# CITY OF ALBUQUERQUE

**Re: Lot 6 Block 4 Unit 18 Volcano Cliffs, S.A.D. 228  
6600 Papagayo NW  
Request for Permanent C.O. – Not Accepted  
Engineer's Stamp dated: 1-2-18 (D10D003J6)  
Certification dated: 1/23/19**

Based on the Certification received 1/23/19, this site cannot be accepted for release of Certificate of Occupancy by Hydrology until the following comments are addressed.

LEGEND

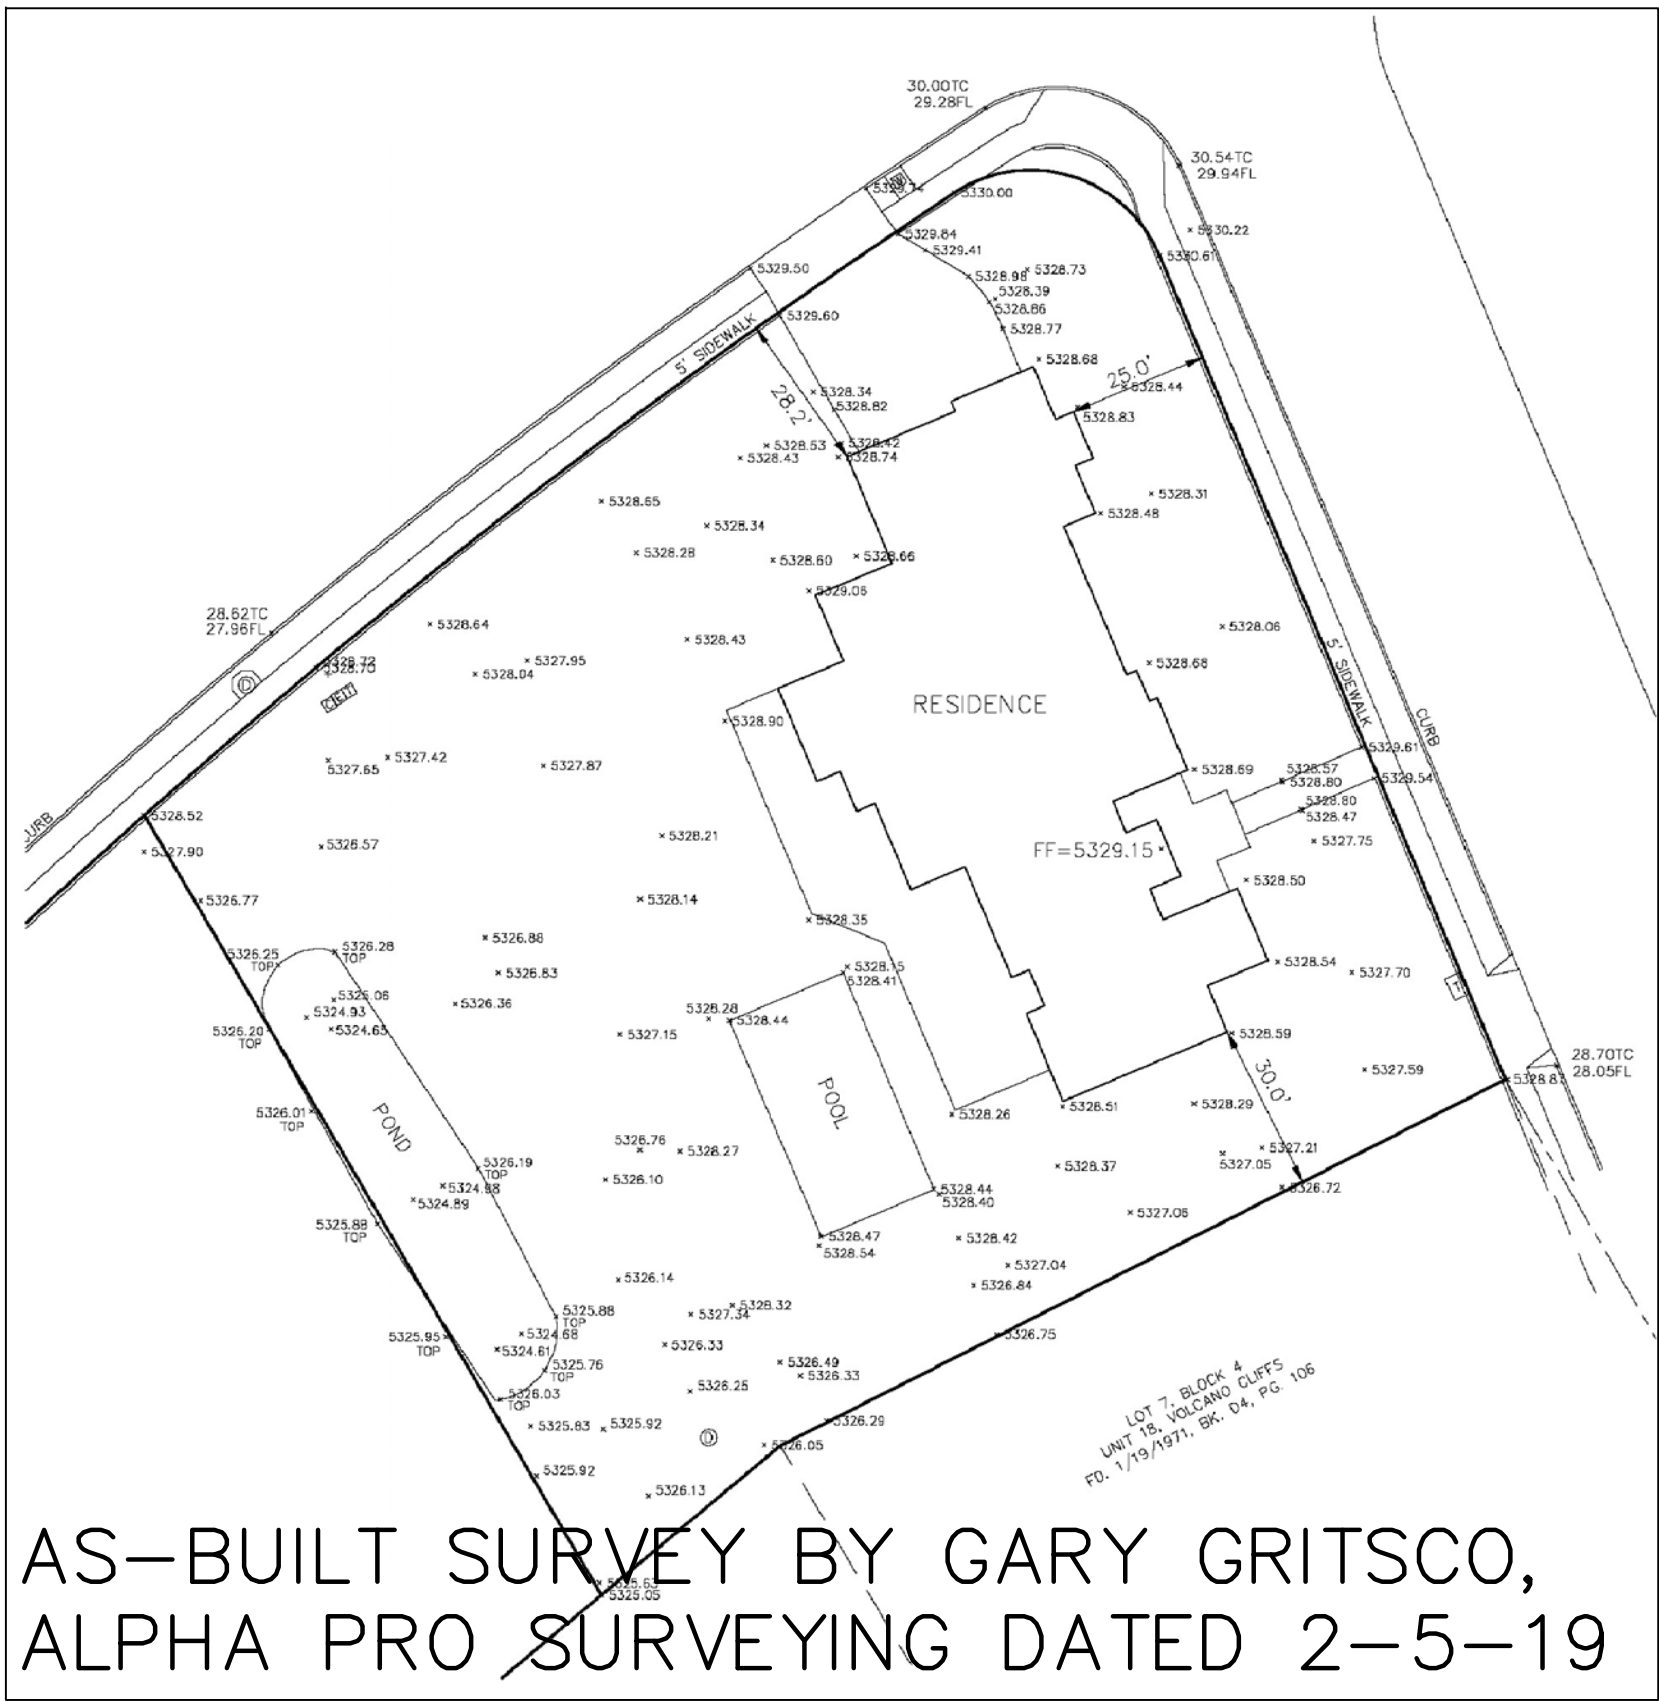
- Provide the new plat for this address, it appears that the lot line was moved.
- Provide the location of the 20' SD easement, one of the hatched lines are missing.
- Provide the new calculations including the pool area. Treatment D should have increase along with the ponding area.
